Our ref: HA/2024/125722/01-L01
Your ref: AL/11/24/OUT
Date: 11 March 2024

HYBRID APPLICATION CONSISTING OF: 1) OUTLINE PERMISSION FOR ALL MATTERS RESERVED (EXCEPT ACCESS) FOR UP TO 400 NO DWELLINGS AND ASSOCIATED WORKS AND 2) FULL PLANNING PERMISSION FOR ALTERATIONS TO SITE ACCESS OFF WESTERGATE STREET AND THROUGH PINE CLOSE AND EAST-WEST LINK ROAD INCLUDING A BRIDGE OVER THE LIDSEY RIFE. THIS APPLICATION ALSO LIES WITHIN THE PARISH OF BARNHAM, FALLS WITHIN STRATEGIC SITE SD5, CIL ZONE 1 (ZERO RATED), AFFECTS THE SETTING OF LISTED BUILDINGS, AFFECTS THE CHARACTER AND APPEARANCE OF THE EASTERGATE CHURCH LANE CONSERVATION AREA, AFFECTS PUBLIC RIGHTS OF WAY. THIS APPLICATION IS THE SUBJECT OF AN ENVIRONMENTAL STATEMENT LAND EAST OF WESTERGATE WESTERGATE

Environment Agency Position

ELEVATION A-A
SCALE 1:75

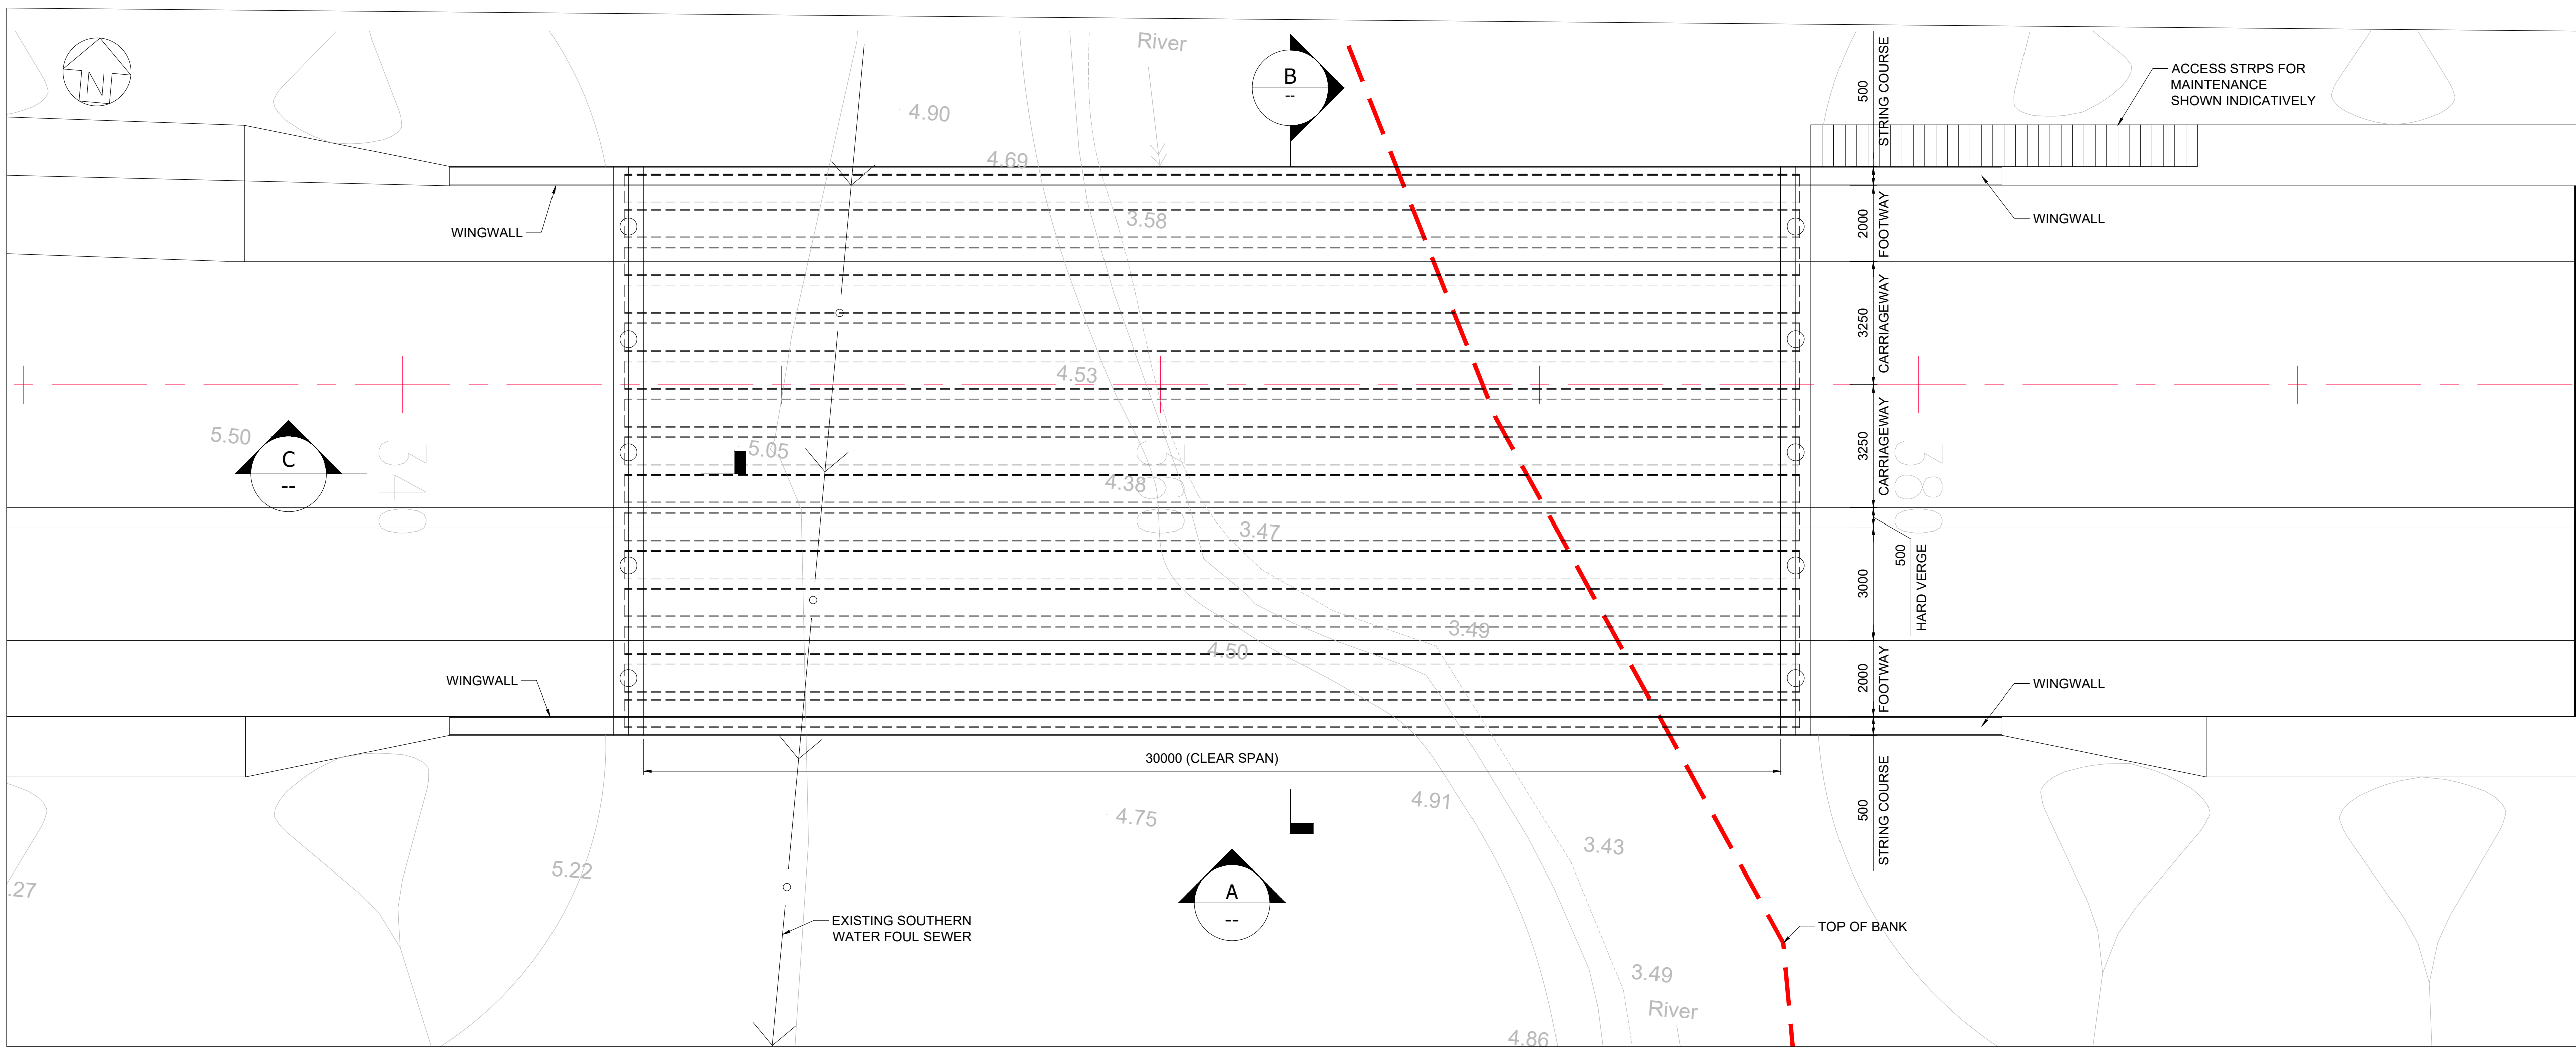
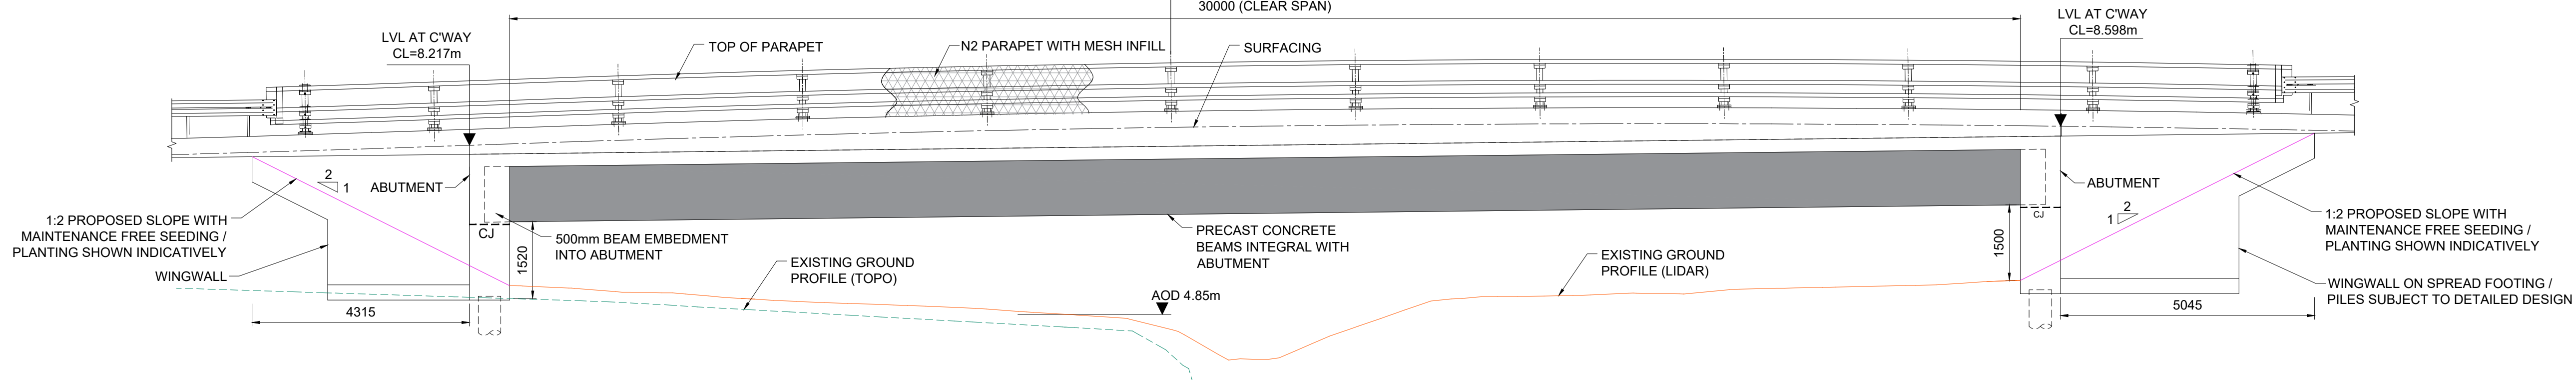
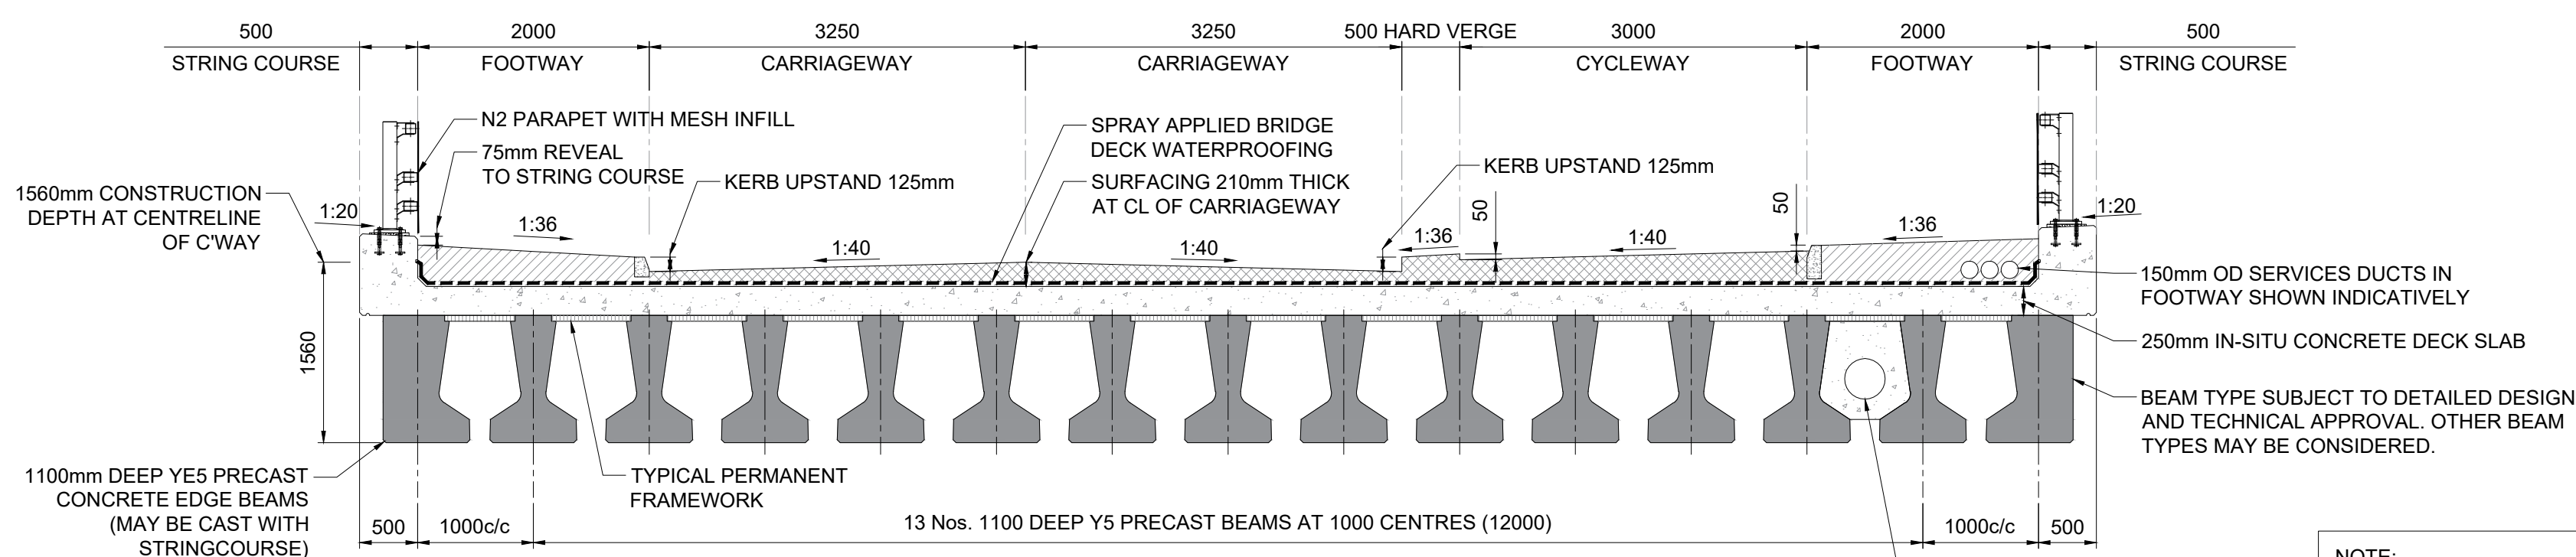
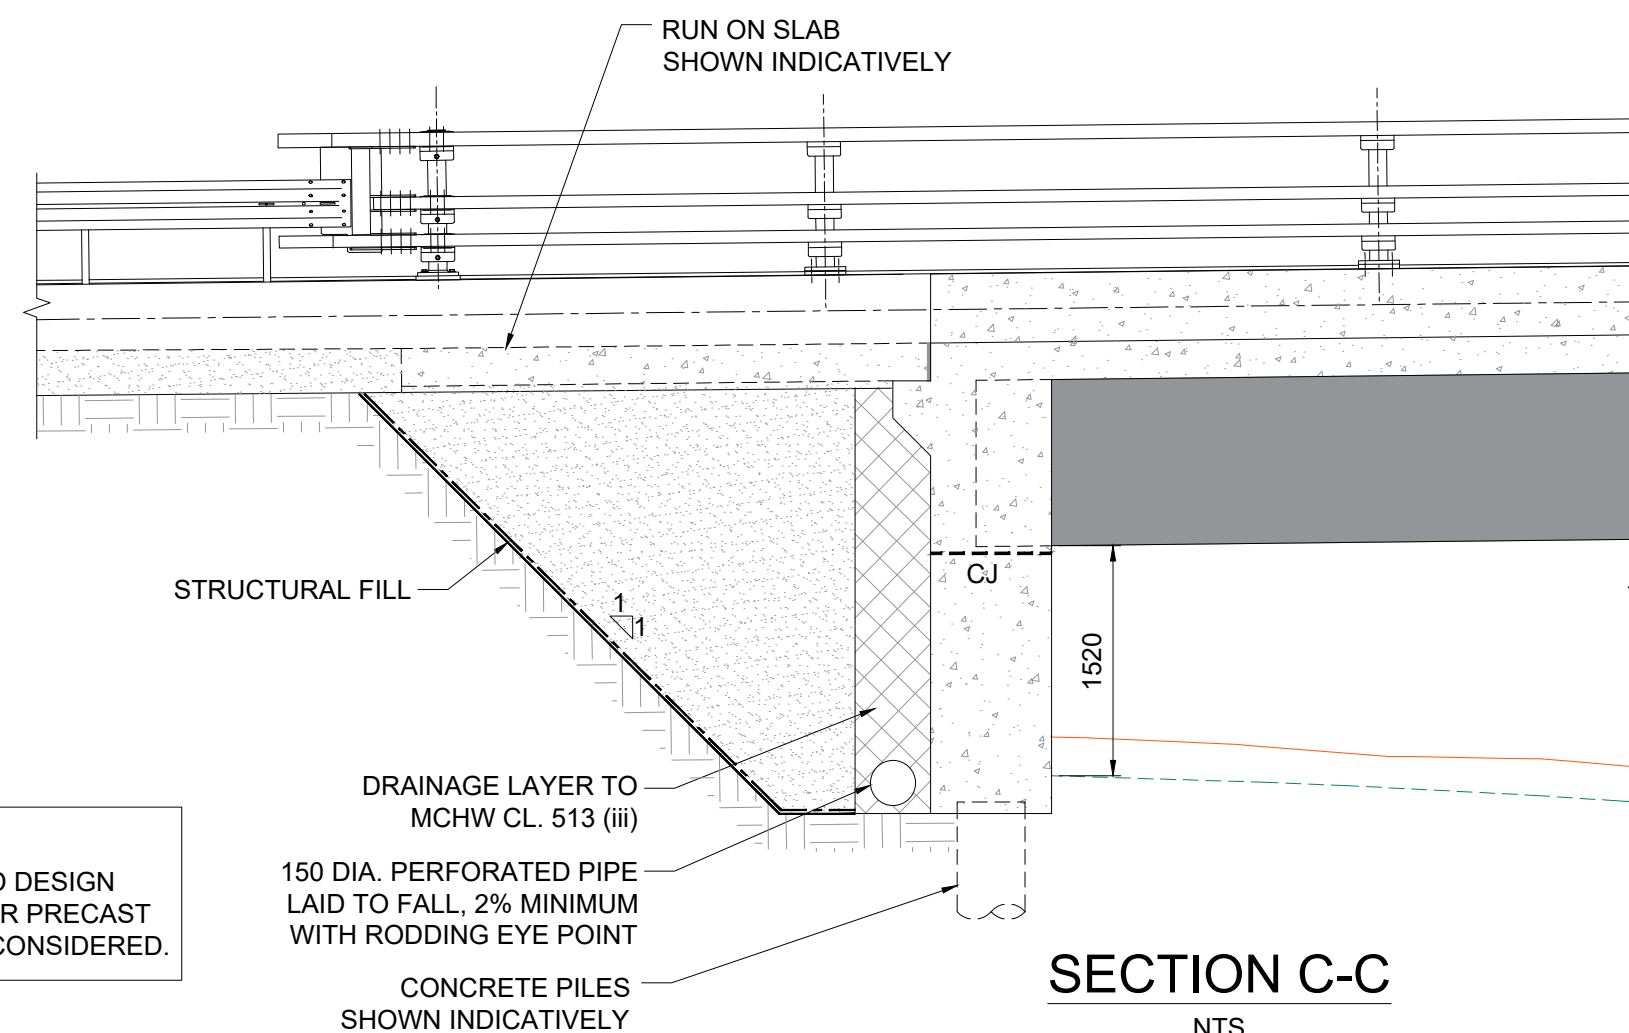
In **order to provide a fully informed response** of the flood risk at this site, we will need to **review the cut version of the Environment Agency (EA) model** (referred to as the 'Westergate Model'). The review will be passed to our national Evidence and Risk Team. The model files should be submitted to the LPA and the EA for review. Until this model has been assessed, we cannot properly advise on the flood risk associated with the proposed crossing of the Lidsey Rife.

We would agree that as mentioned, an 8m access to be provided alongside the Lidsey Rife would be welcomed. We would also note that it is likely that any outfalls into the Lidsey Rife would require a Flood Risk Activity Permit, the details of which are included below within this response, as will the rife crossing.
